Final Acceptance (FA) Punchlist
EPC - DPW - Stormwater Section

Project Name:	Lorson Ranch East F1
EDARP Filing Number(s):	SF188, CON1958
ESQCP Number:	ESQ182
Attendees:	DPW SW: Natasha Grimaldo, Ben Jones Stormwater Engineers: Mikayla Hartford and Glenn Reese walked the site on 2/28/2023. Developer: John Chavez
Date of Walk-Thru:	2/14/2023
Walk-Thru Number:	1 st

Findings to be addressed prior to scheduling a follow-up walk-thru:

DATE:  
JUNE 12, 2018

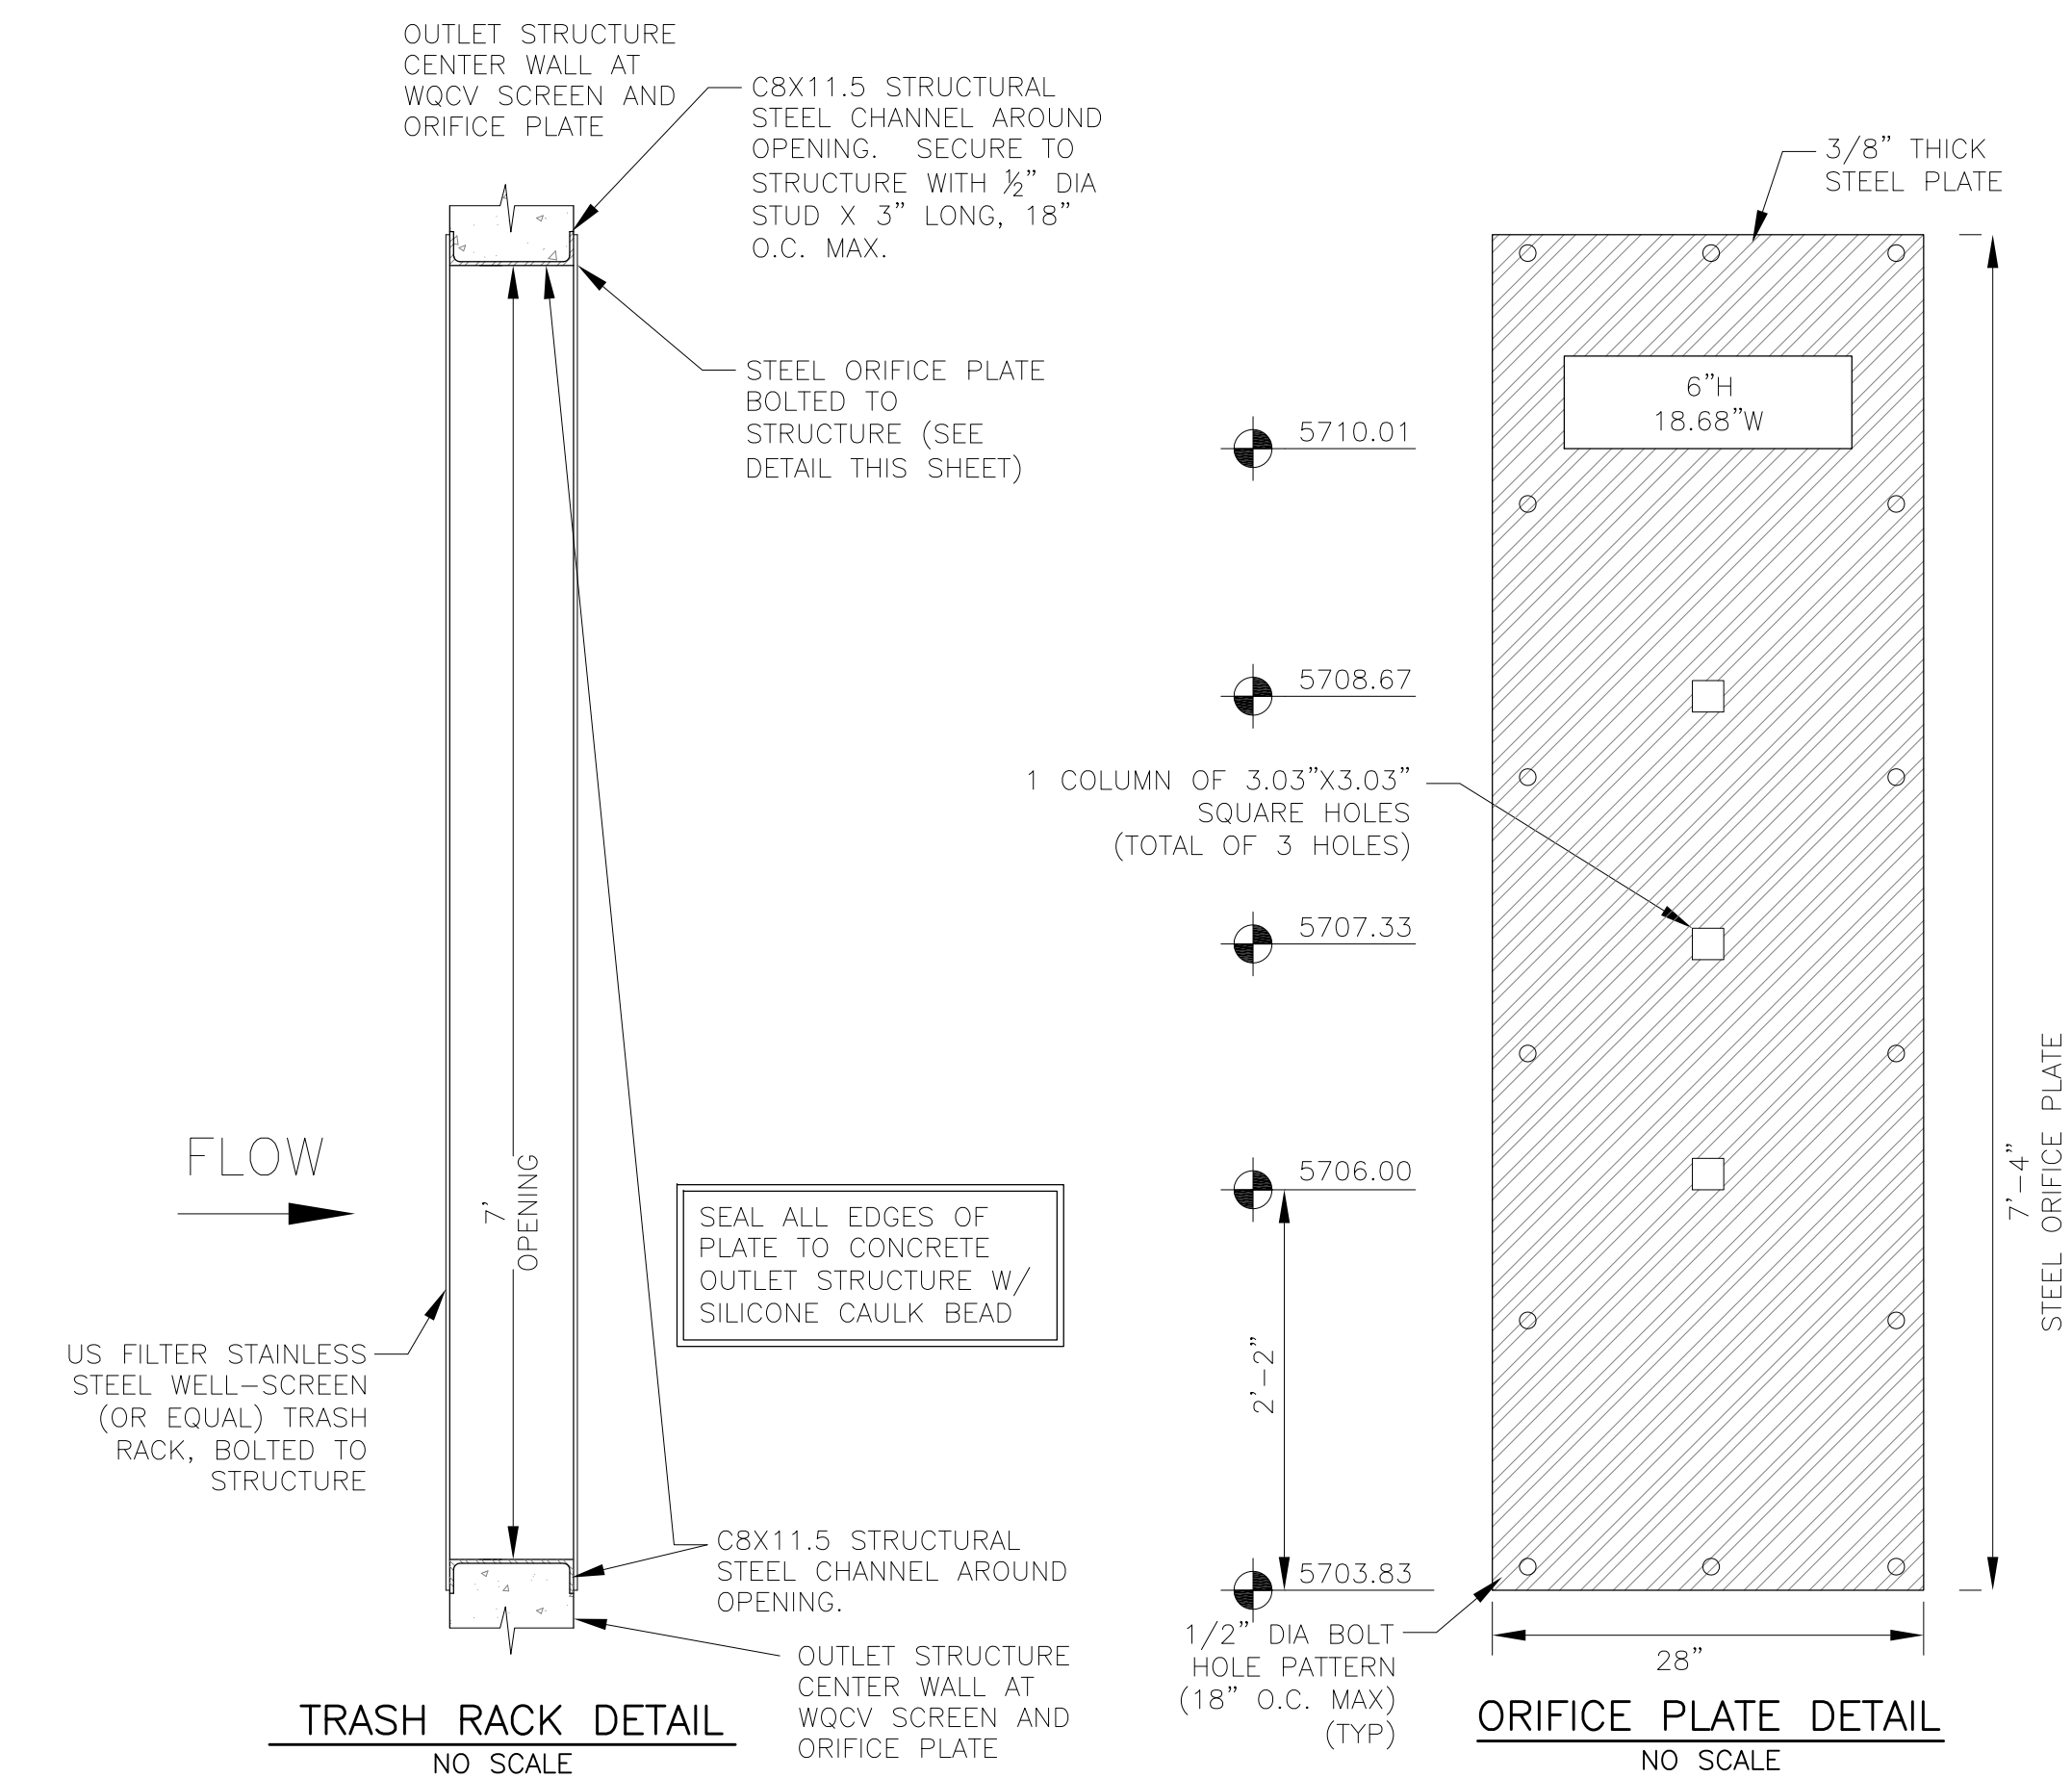
- Remove sediment and debris from outlet pipe.
- Remove rock sock from forebay notch in forebay B.
- Implement 9" D50 rip rap per specification on forebay A and B. Reference sheet C9.2 of CDs.
